RE: 2113 Coal Ave. SE
Grading and Drainage Plan
Engineer's Stamp Date: 03/04/21
Hydrology File: K15D106

Based upon the information provided in your submittal received 03/09/2021, the Grading and Drainage Plan is approved for Grading Permit.

ENGINEER'S SEAL  DAVID SOULE P.E. #14522	LOT 17 BLOCK 6 BUENA VISTA HTS 2113 COAL AVE.	DRAWN BY DEM
	GRADING AND DRAINAGE PLAN	DATE 2-25-21
 Rio Grande Engineering P.O. BOX 53294 ALBUQUERQUE, NM 87199 (505) 321-8099	LOT 17 BLOCK 6 BUENA VISTA HTS.DWG	SHEET # 1 OF 2
	3/4/21	JOB #

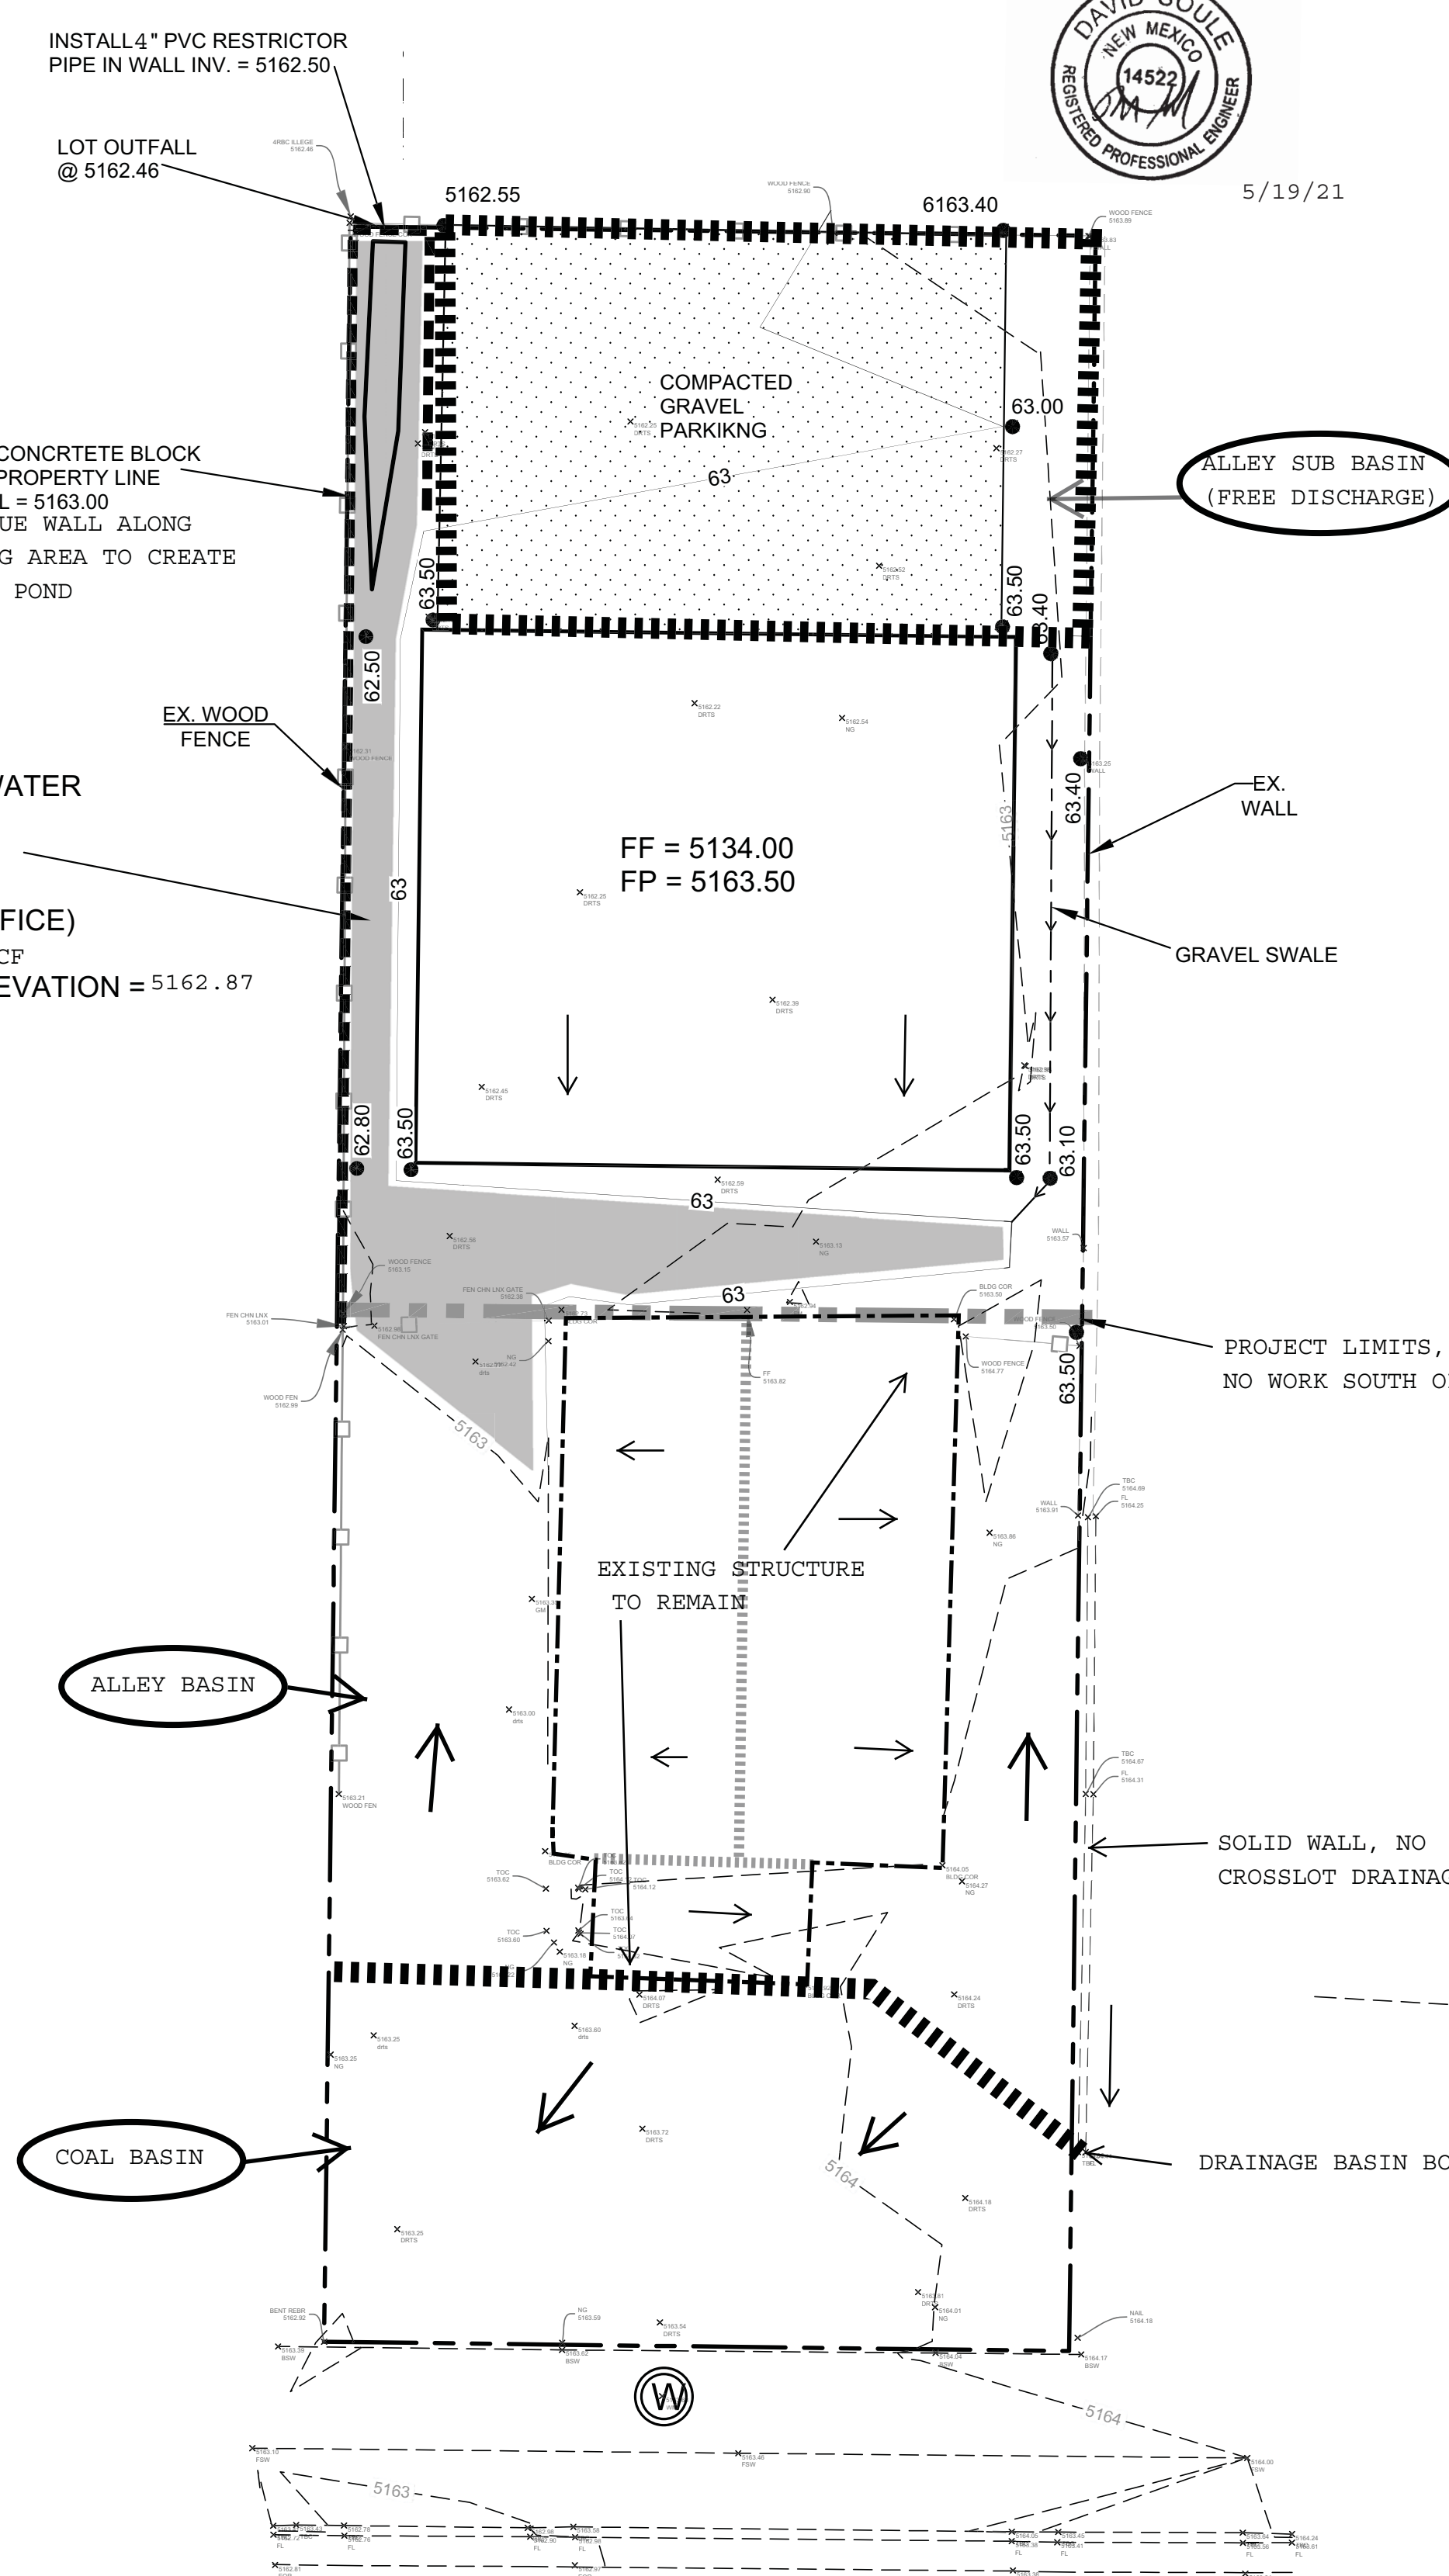
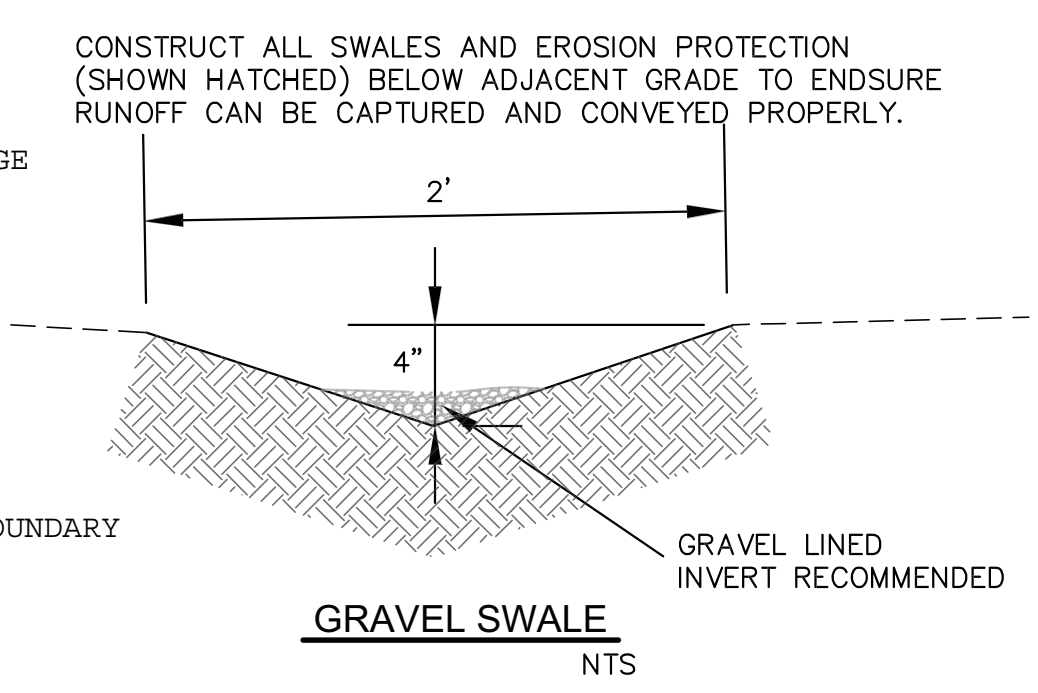
I need the following information prior to approving this project. Please let me know. Also please change your address to Coal Place SW. Coal Ave diverts to the south prior to the site.

Alley survey information????? I need existing grade information at least 20 feet east and west of the property lines. I think the alley slopes to the west but I need some confirmation. Also what is the condition of the alley at this location? I know further to the east the alley is ok. However right here looks like gravel which would have to be brought up to City standards.

Renee, The surveyor did not pick up additional alley shots. I have attached pictures from a site visit. The alley slopes from east to west discharging to Buena vista west of this site. The alley grading is not consistent. but with fencing and grades all the flow stays withing the alley. the grade of alley adjacen to this site is 1.6%
David
